LOCATION 471-473 Cumberland Ave.

City of Portland, Maine - Building or Use Permit Application

Location of Construction: 471 CUMBERLAND AVE	Owner Name: DAJ INC	Owner Address: PO BOX 6577	Phone:
Business Name:	Contractor Name: KMD Services/ James Maclean	Contractor Address: Portland	Phone:
Lessee/Buyer's Name	Phone:	Permit Type: Alterations - Multi Family	Zone: R6

Proposed Use: Multi-Family Home - Replace side steps/Porch	Proposed Project Description: Replace side steps/Porch
--	--

471 CUMBERLAND AVE  
PTLD.

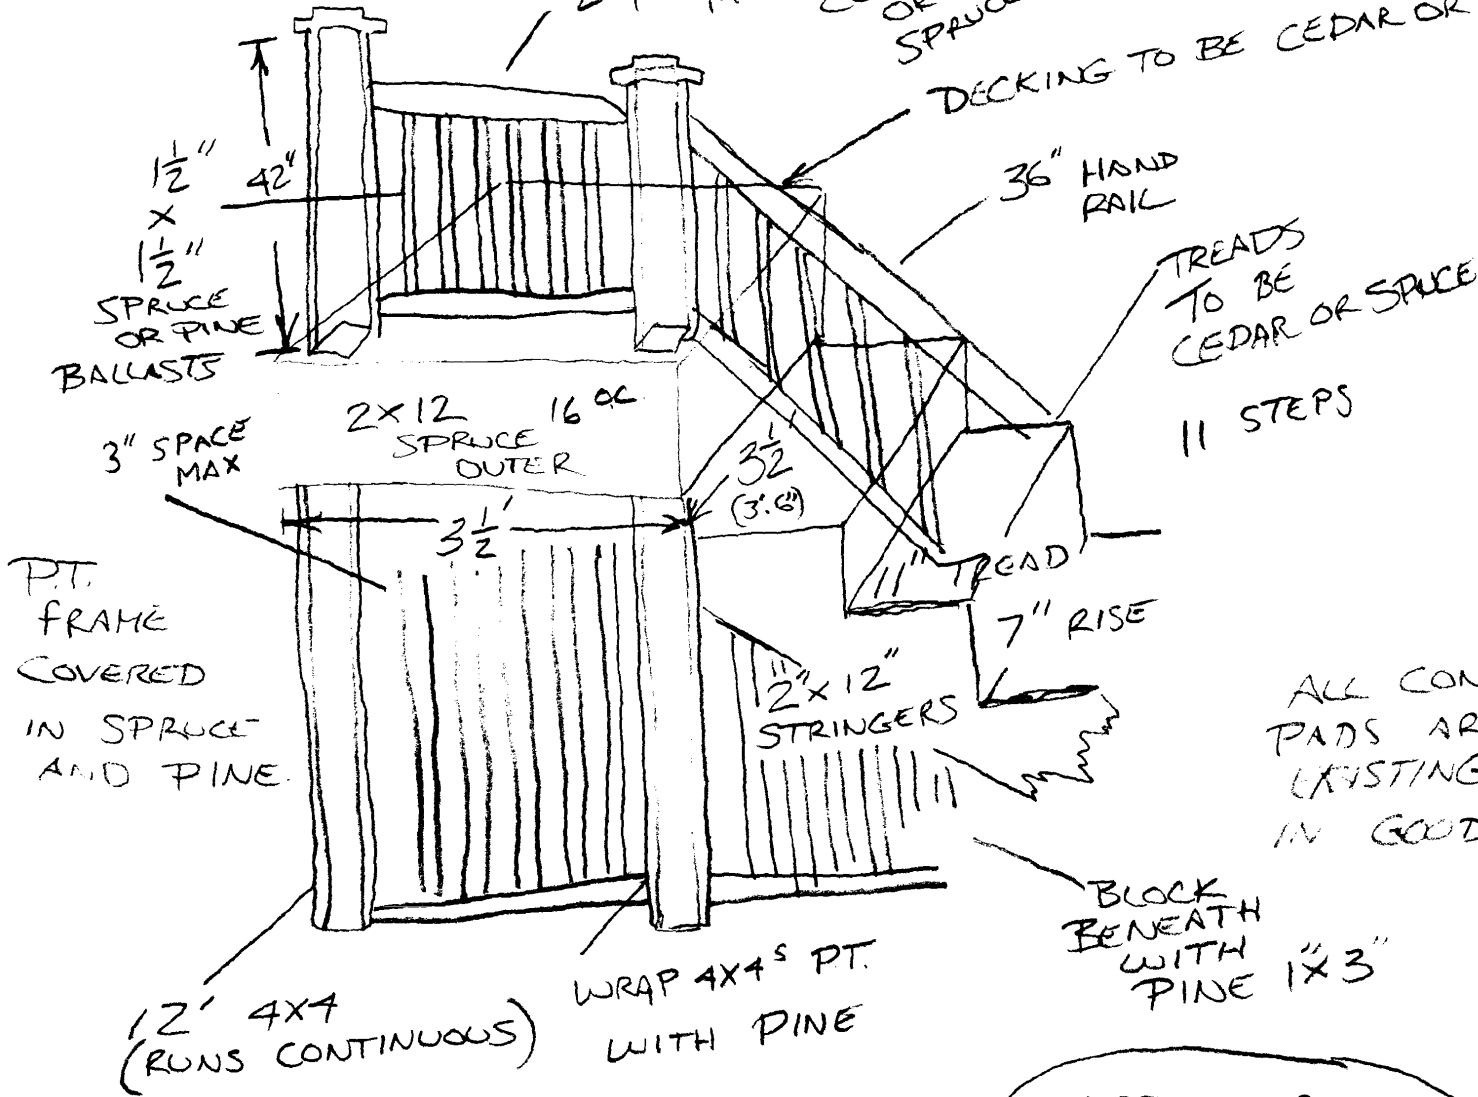
Dept: Building **Status:** Approved with Conditions **Reviewer:** Chris Hanson **Approval Date:** 06/08/2007
Note: **Ok to Issue:**
 1) As discussed during the review process, ballusters must be spaced with less than a 4" opening between each.
 2) ANY exterior work requires separate review and approval thru Historic Preservation
 3) Open risers are permitted, provided that the opening between treads does not permit the passage of a 4" diameter sphere.
 4) Fastener schedule per the IRC 2003
 5) Application approval based upon information provided by applicant. Any deviation from approved plans requires separate review and approval prior to work.
 6) Guards must be 42 inches in height with openings less than 4 inches. Graspable rails must be installed on both sides of the stair guard. Stair treads shall not be less than 11". Stair risers shall not be more than 7".
